WEST SUSSEX COUNTY COUNCIL CONSULTATION

TO:	Arun District Council FAO: Simon Davis
FROM:	Highways, WSCC
DATE:	12/08/2020
LOCATION:	Land Adjacent to Tars Farmhouse, Church Lane, Barnham, PO22 0DB
SUBJECT:	BN/39/20
DATE OF SITE VISIT:	10/07/2020
RECOMMENDATION:	☒ Advice ☐ Objection ☐ Modification ☐ No Objection ☐ More Information ☐ Refusal
S106 CONTRIBUTION TOTAL:	£ N/A

The proposal is for the construction of 4 no. 4 bedroom dwellings with parking and access improvements.

GARAGES - Plots 1 & 3

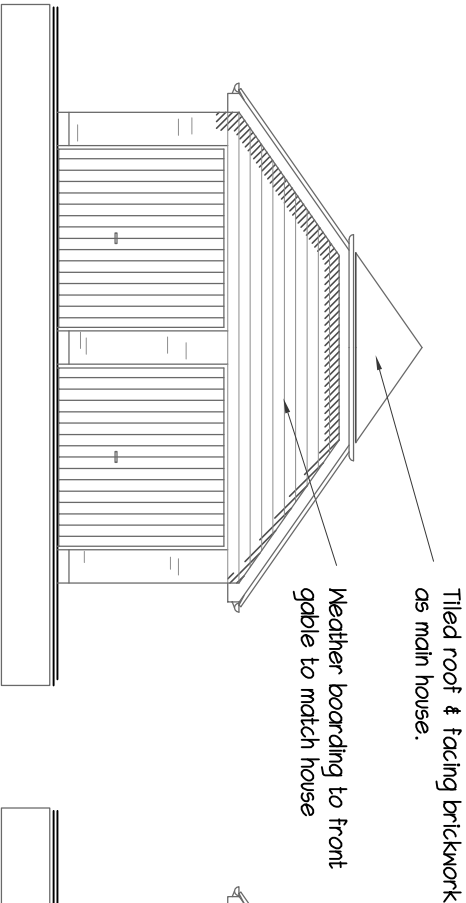
- Garage space – Each garage measures a minimum of 6 x 6 metres,

For the LHA to consider a garage to provide a parking provision of 0.5, the garage must first measure a minimum of 3 x 6 metres (as per APS) internally. As such, the garage would be considered to provide a 1 parking provision per dwelling.

Figure 7: Swept Path Assessment

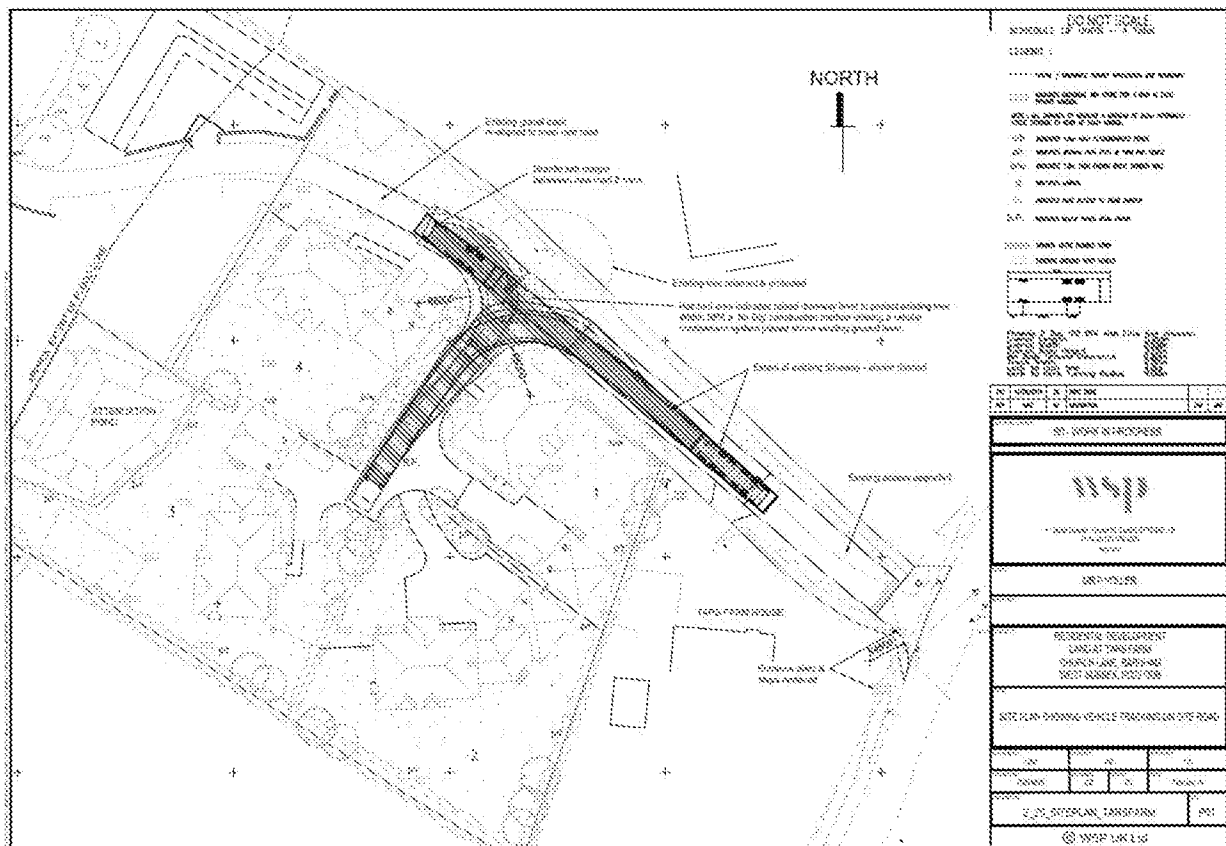
The applicant has demonstrated a turn on site. The proposed access drive is to accommodate such a provision. This conforms to Manual for Streets (MfS) Guidance for a turning area.

No part of the development shall be first occupied until the vehicle turning space has been constructed within the site in accordance with the approved site plan. This space shall always thereafter be kept for their designated use.
